CEMEX

COMMENTS ON EXA'S FIRST WRITTEN QUESTIONS

HIGHWAYS ENGLAND'S RESPONSE

1. EXAMINING AUTHORITY'S WRITTEN QUESTIONS AND REQUESTS FOR INFORMATION M4 JUNCTIONS 3 TO 12 SMART MOTORWAY

-  100 YRS CC FLOOD LEVEL
-  EXISTING PROFILE
-  PROPOSED PROFILE
-  FLOOD COMPENSATION
-  FLOOD STORAGE LOSS

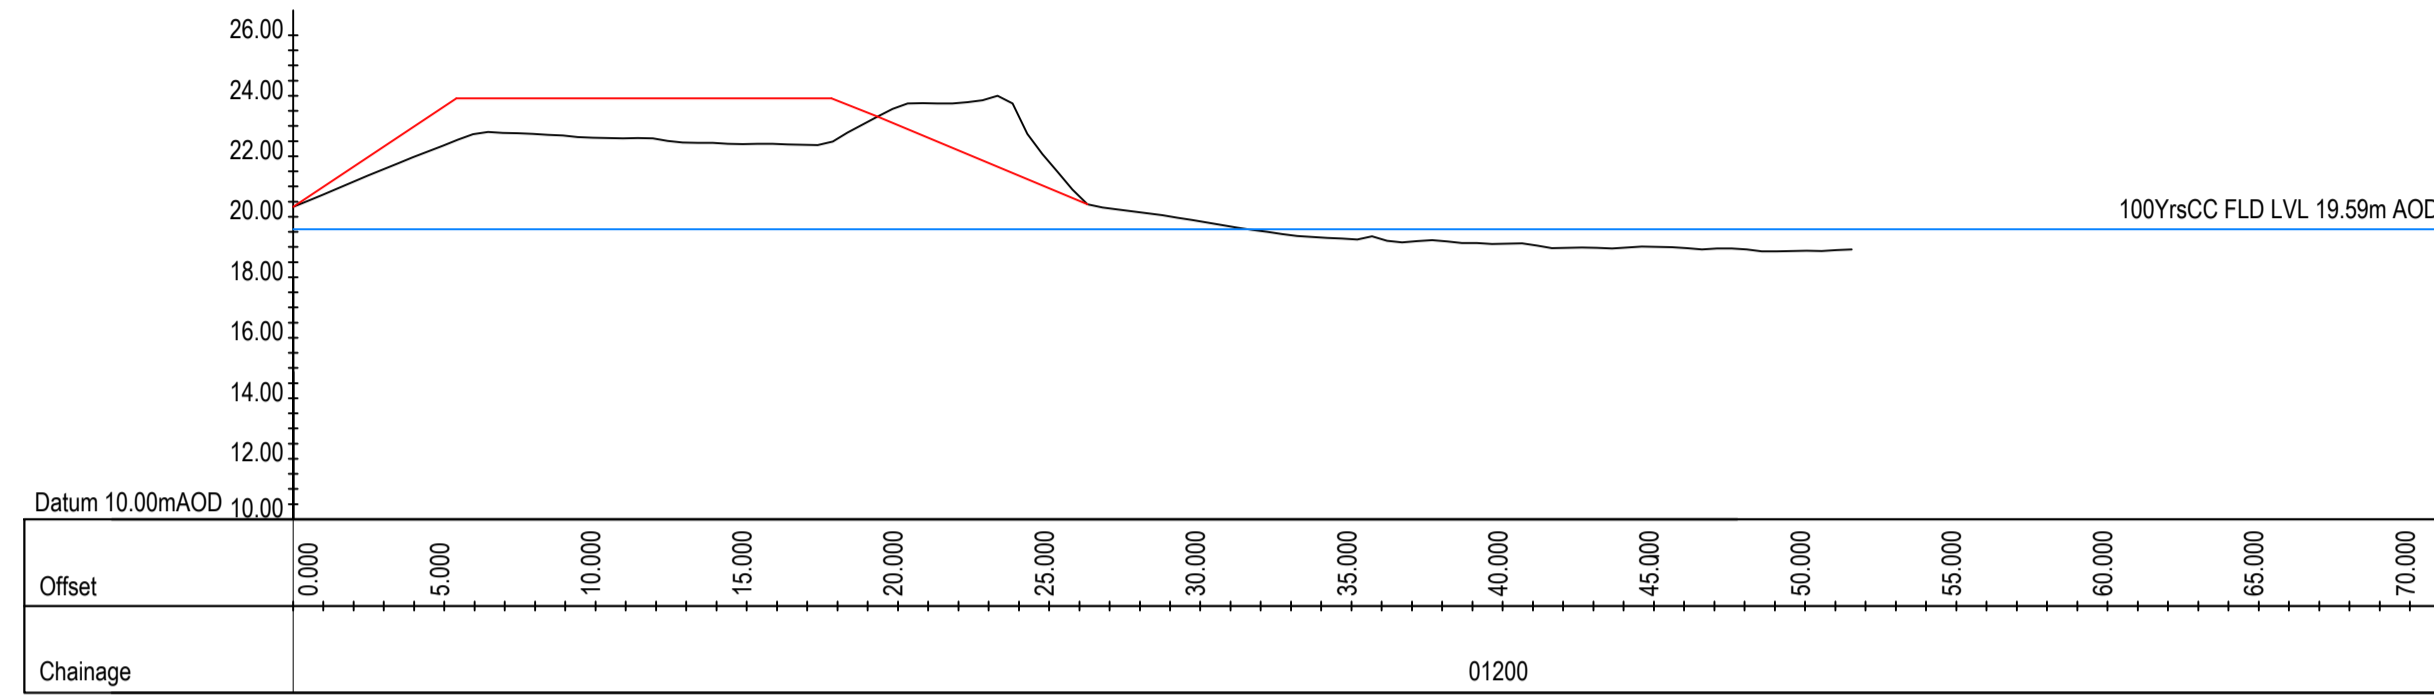
1.5 *It is understood by CEMEX that the DCO application by Highways England is to reconstruct the Riding Court Road bridge over the M4 offline, which should ensure less disruption to traffic flows along Riding Court Road. CEMEX UK Operations Ltd is supportive of this offline construction. Lands Plans Sheet 24-31 Drawing TR010019 -2. indicates this offline construction.*

1.7 *The plans show that in terms of the extraction area there is no overlap between the two schemes, but the red line for the Order Limit - Work No 22a does enter the application site and coincide with land where CEMEX would have tree protection and soil storage and amenity protection bunding. The Order Limit for Highways England's application also covers Riding Court Road, CEMEX's access onto Riding Court Road, the James Meadow Roundabout and the lower end of Ditton Road. At this stage from Highways England's application documents and EIA it is unclear why this land is included within the M4 scheme*

1.5.1 Highways England confirms that the proposed works at Riding Court Road overbridge are to provide an offline replacement structure to the north-west side of the existing bridge. This will enable access across the M4 to be maintained throughout the construction period.

1.7.1 Highways England has reviewed the drawings which CEMEX has provided in response to the Examining Authority's first written questions (Question 9.24) and note that there are three areas where the Order Limits for the Scheme coincide with the site of PP13/01667.
